# KITITAS COUNTY

### MEMORANDUM

DATE: August 7, 2020

SUBJECT: Zipperer Short Plat

SHEET
1
OF
2

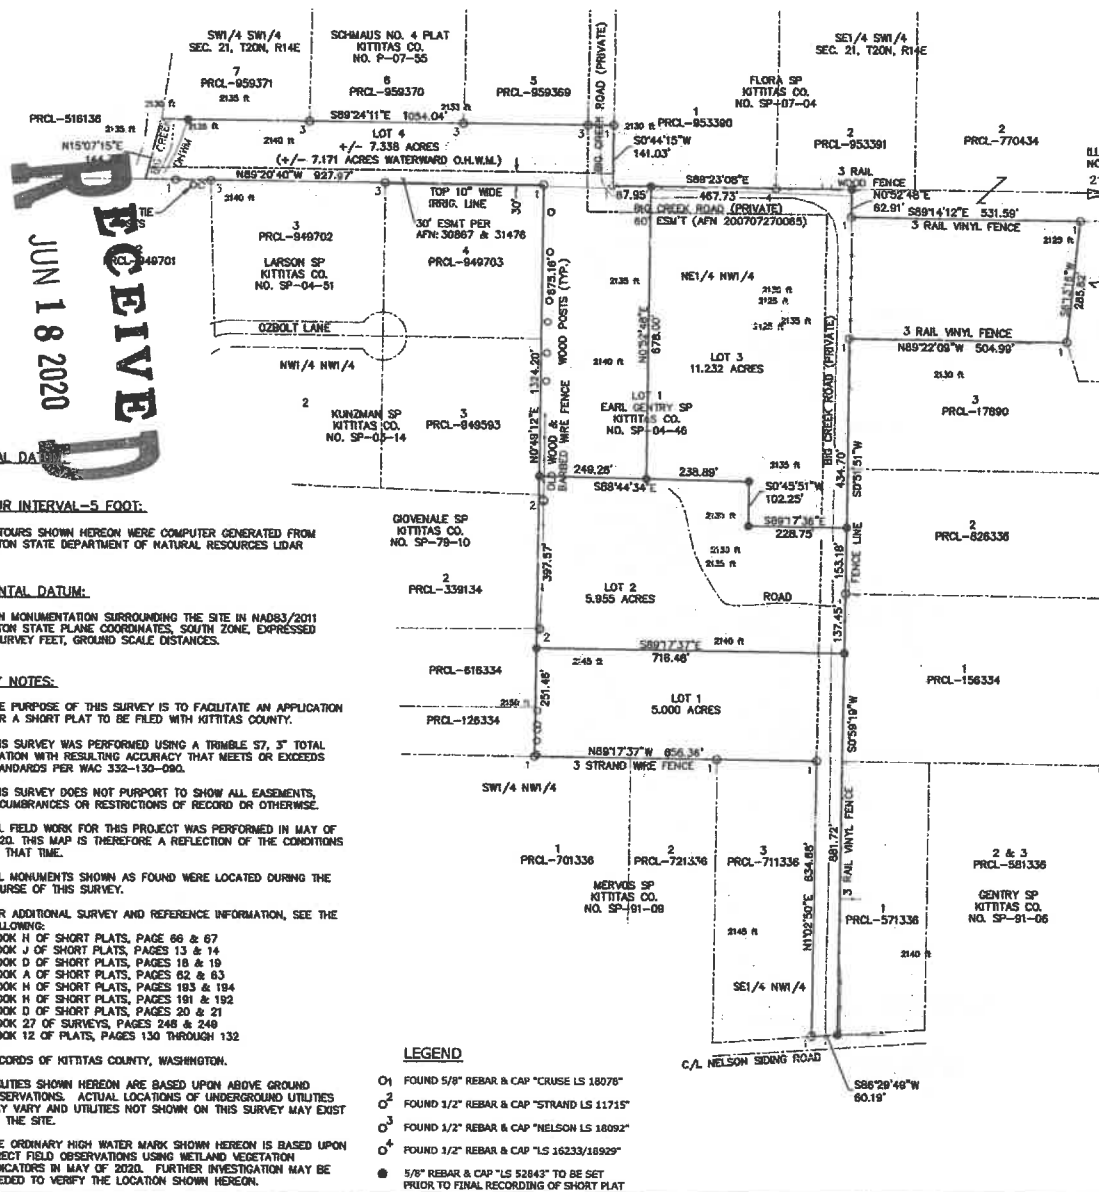
1. There is a small closure error in the closure report for the parent parcel, in the vicinity of the NE corner of Lot 1. This error does not occur in the individual closure reports for Lot 1 and 2, therefore it is assumed to just be a error in tracing parcel boundaries. No correction required.

2. Basis of bearing will need to be addressed.
3. Note the distance the fenceline encroaches into Lots 2 and 4.
4. Show Nelson Siding road as a "60' wide county right of way – paved"

5. "tick marks" to the angle point that is on the East side of Lot 2 would be useful to clarify where the angle occurs.
6. There is a requirement to show ties to ALL found corners. As I believe some of the corners may be included purely as visual reference, I do not feel this is required. As the Section is not entirely shown and delineated, it is likely that the found property corners were utilized as controlling evidence. A note explaining the survey monuments held (and those monuments tied) would be beneficial.

7. Typo in the existing legal description "inn".
8. Some text obscured by crossing linework.
